**SRG ENGINEERING, INC.**  
CONSULTING STRUCTURAL ENGINEERS

RE: **Big Moose Harley Addition** METHOD OF SHIPMENT: **1<sup>st</sup> class US mail**

FINAL REPORT OF SPECIAL INSPECTIONS

# FIELD REPORT #1

SHEET **S2**

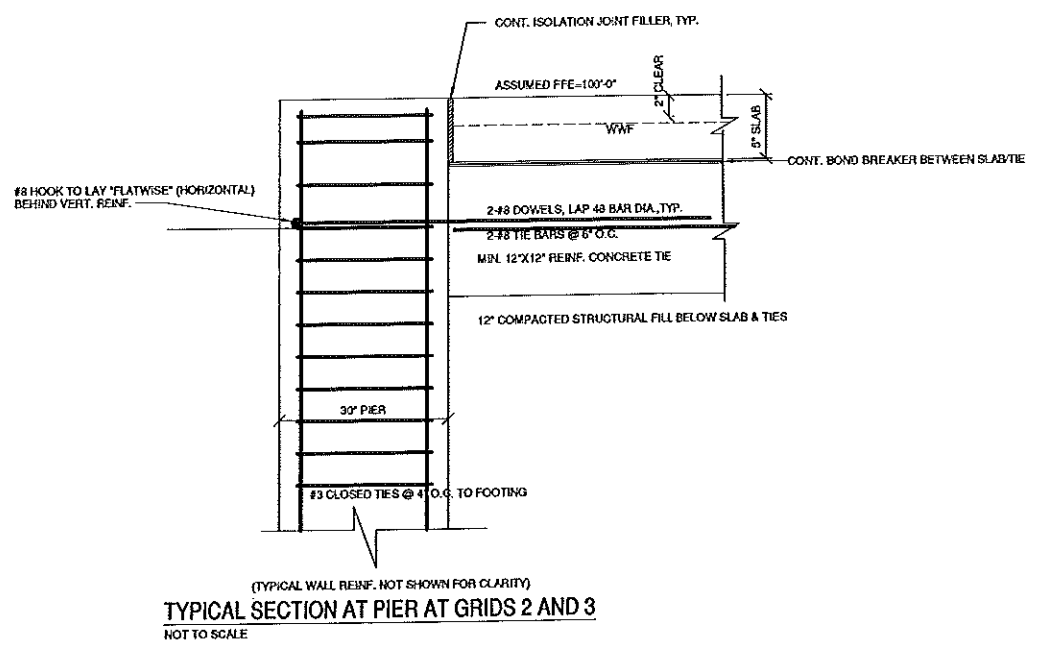
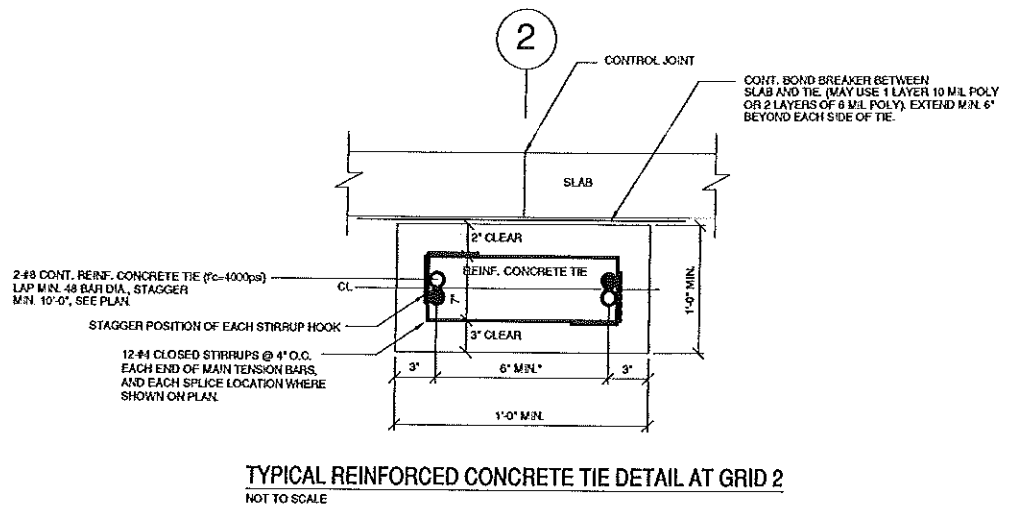
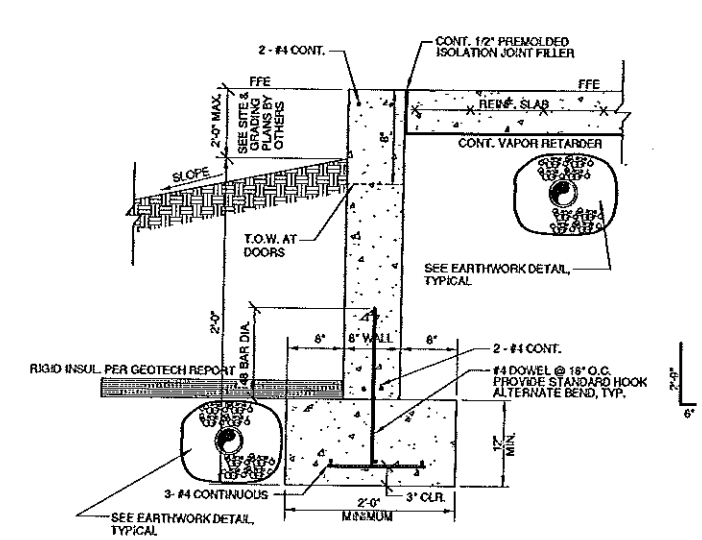
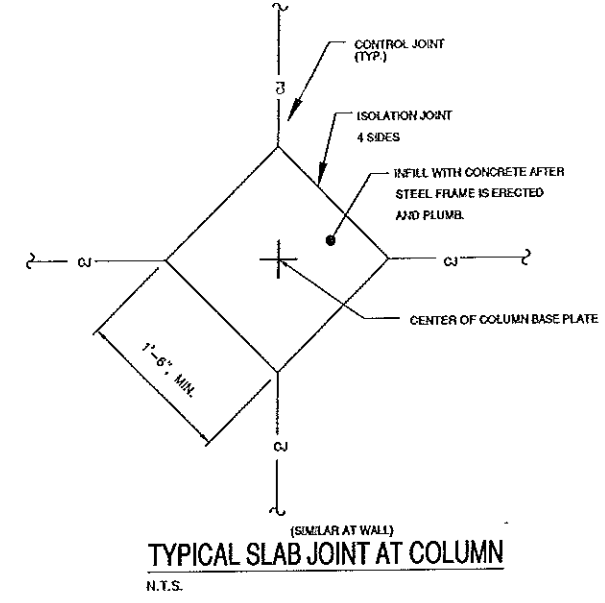
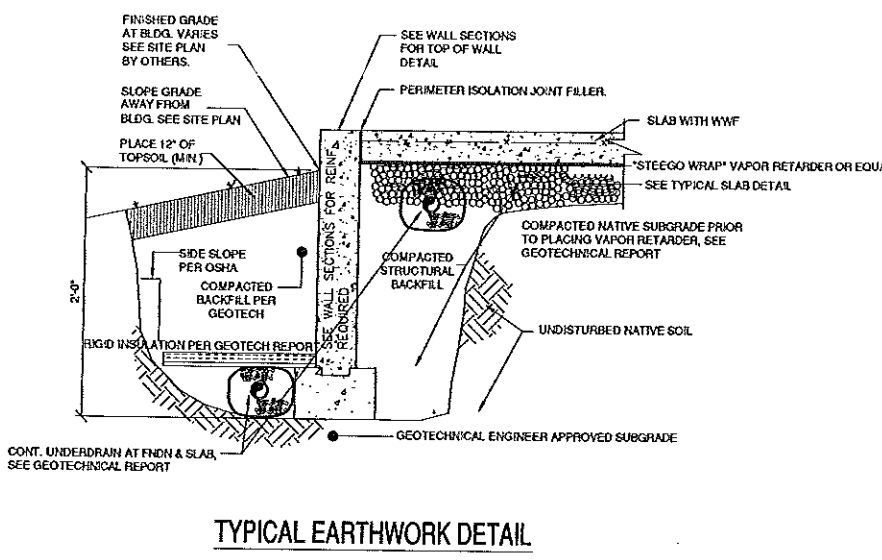
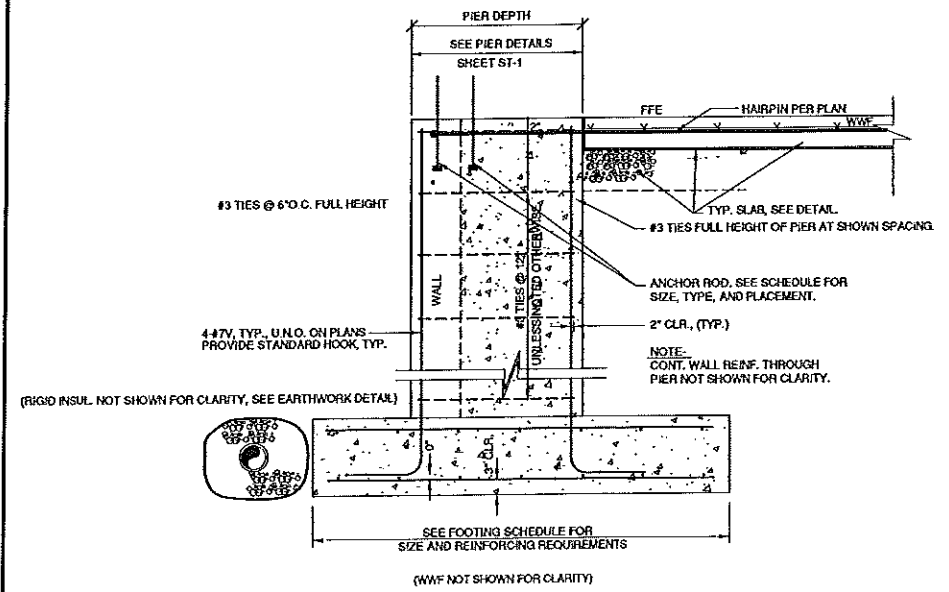
1. Presently the #8 reinforcing bars in the concrete tie extend beyond the end of concrete approximately 20" at the "plan north" end, and 30" at the "plan south end". The plans call for a minimum 48" bar lap. Therefore, new # 8 hooked dowels (hook located inside the 30"x30" pier) must be drilled and epoxy grouted into the concrete ties so there is at least a 48" bar lap for these reinforcing bars. See sheet S2 for details.
2. Presently, there are 2-#4 cont. horizontal at wall locations. There are to be (2) #4 cont. at top and bottom of wall per section 1/S-1 on sheet S3.
3. Some pier vertical bars are short, and must have new dowels placed beside the existing in order to have the correct length. Vertical bars are to extend within 2" from the top of concrete at all locations.
